Comments and Objection re Sunnica Energy Farm site East A and West A and B

Drawing Title
**FIGURE 10-5
NATIONAL CHARACTER
AREAS**

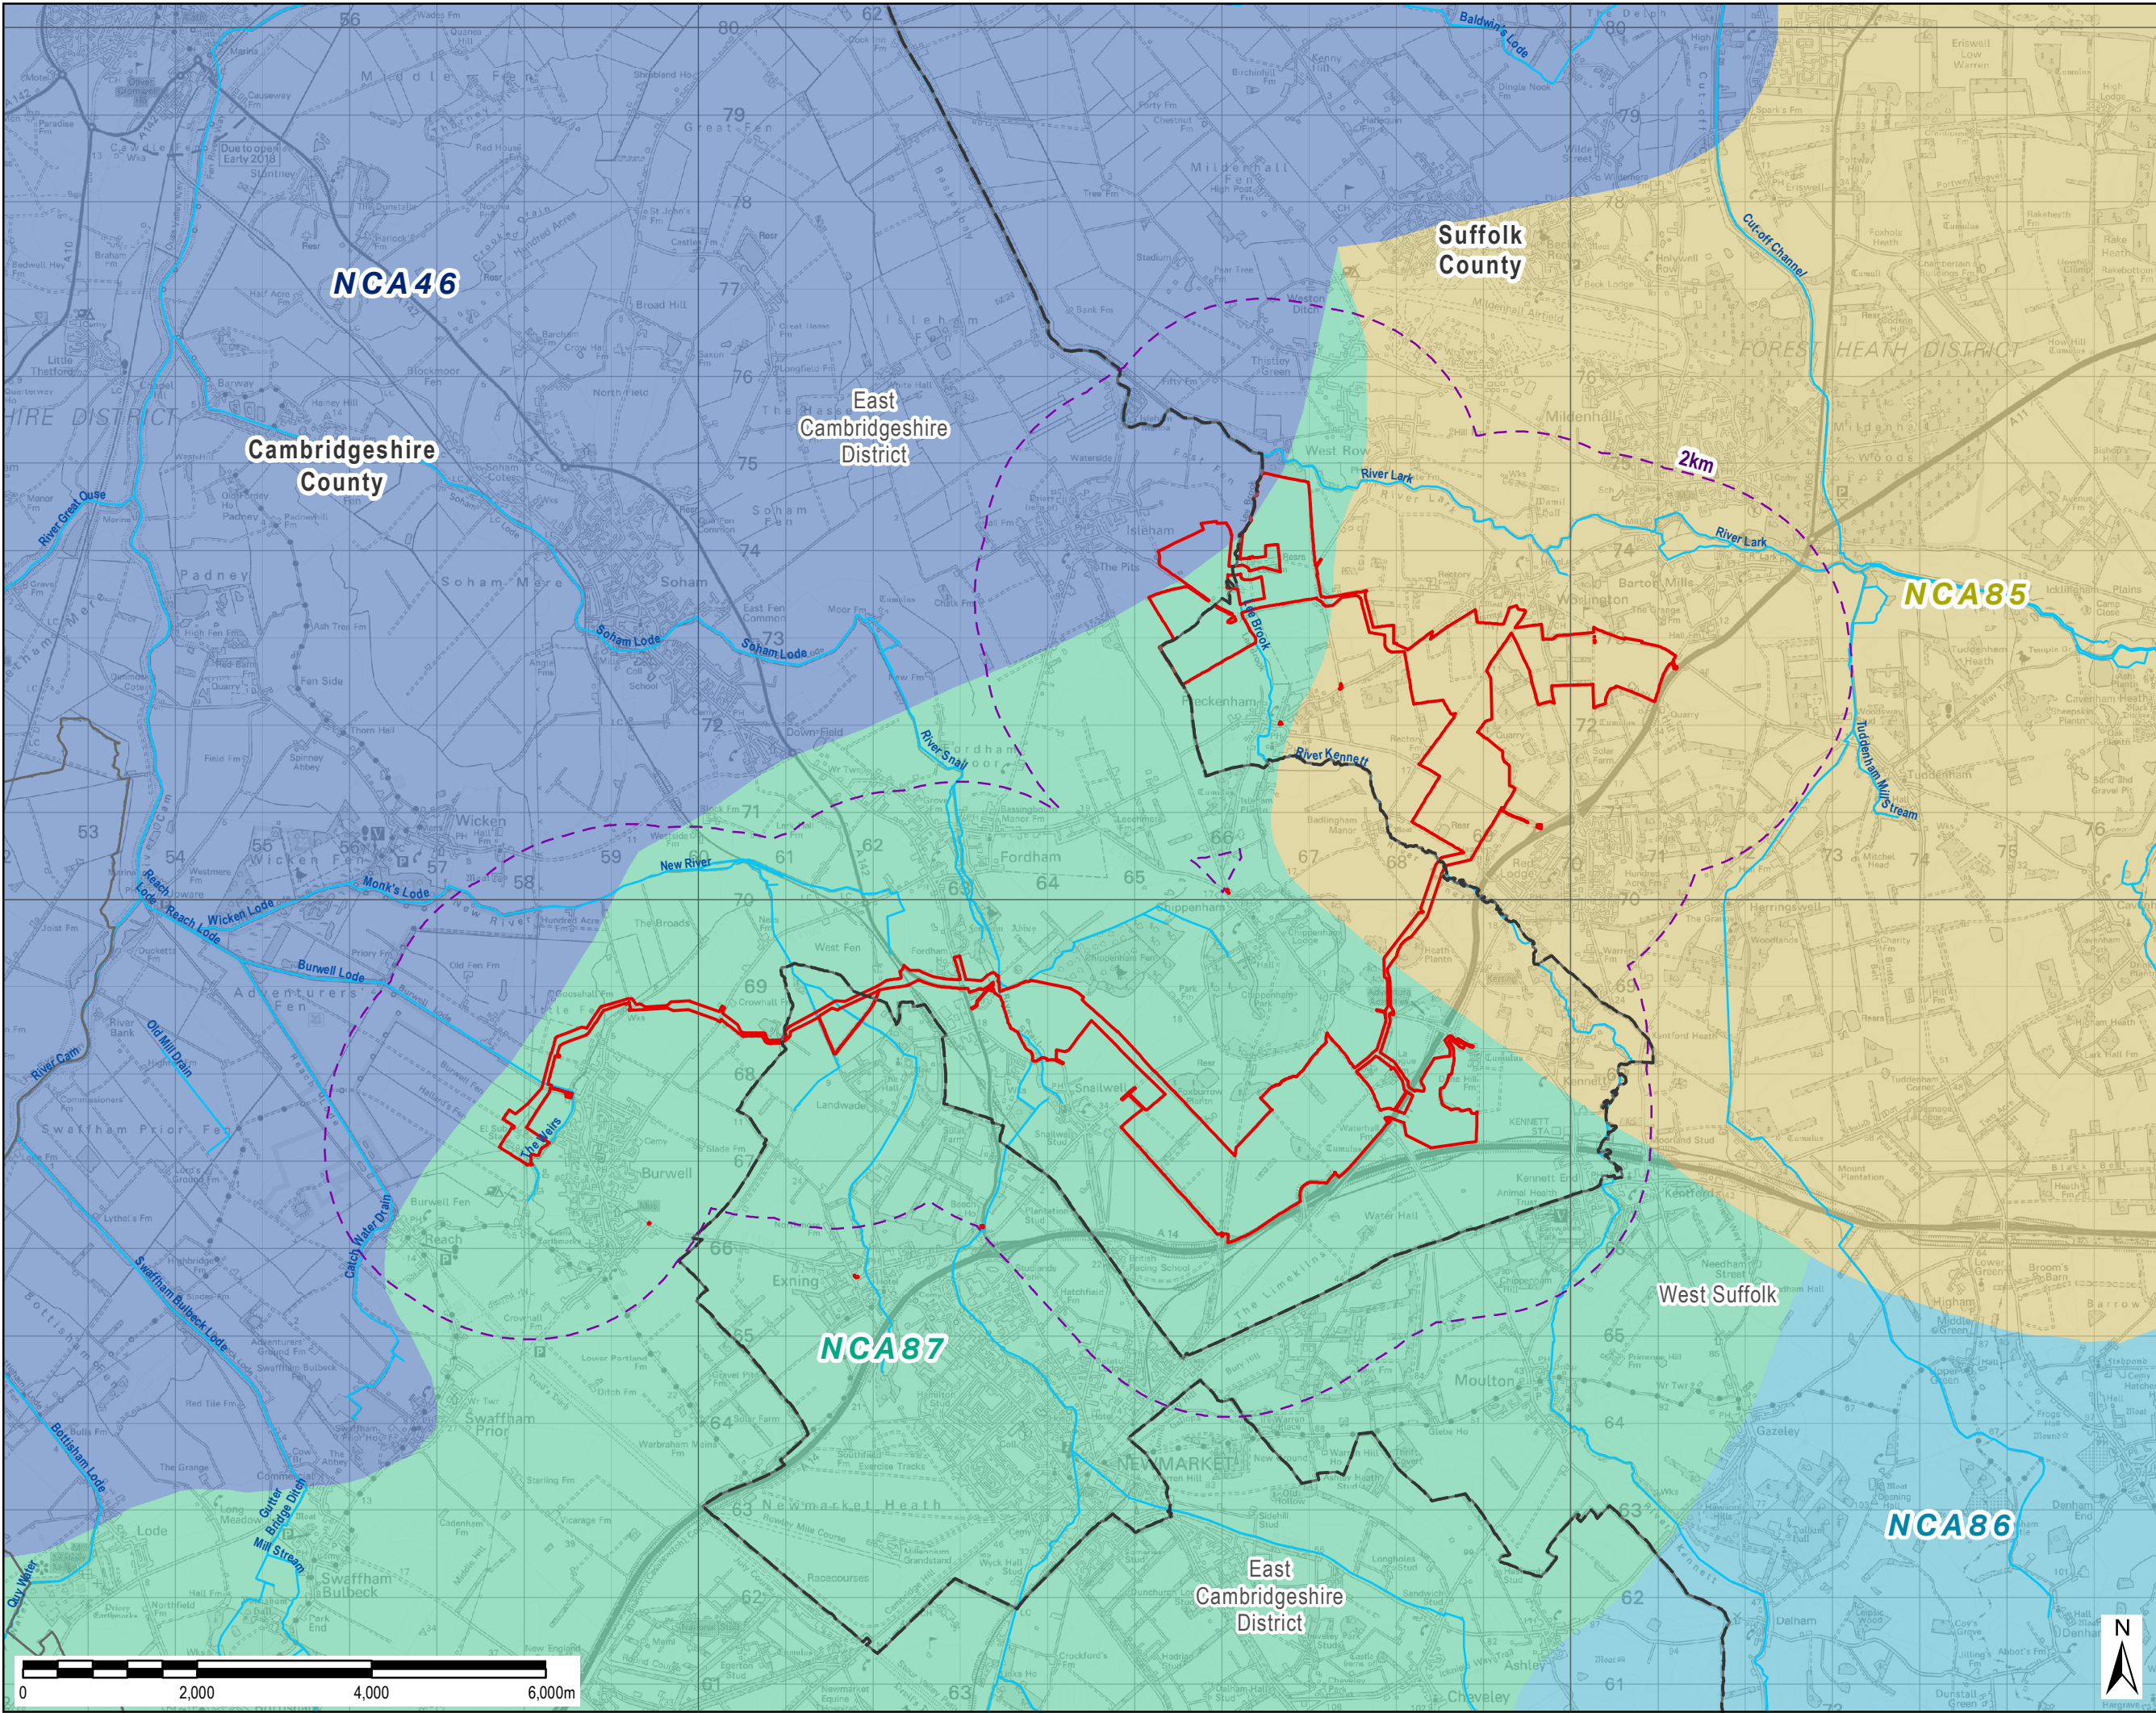
Anything that impacts the simple uninterrupted landscape with few trees and expansive views must be harmful. The percentage of the landscape taken will dictate that impact, as if it is only a small amount then the overall result could be minimal. However, in the case of the sites north and south of Chippenham the energy farm takes a significant amount. In the immediate vicinity probably in excess of 50% once the settlements are factored in along with Chippenham Park (a historical

parkland) and Chippenham Fen (a Nationally important reserve). This is illustrated below when the location of the 'farm' is superimposed on the character area plan.

As it can be seen, given the narrow nature of the character area in this location the energy farm effectively takes the majority of the important open landscape.
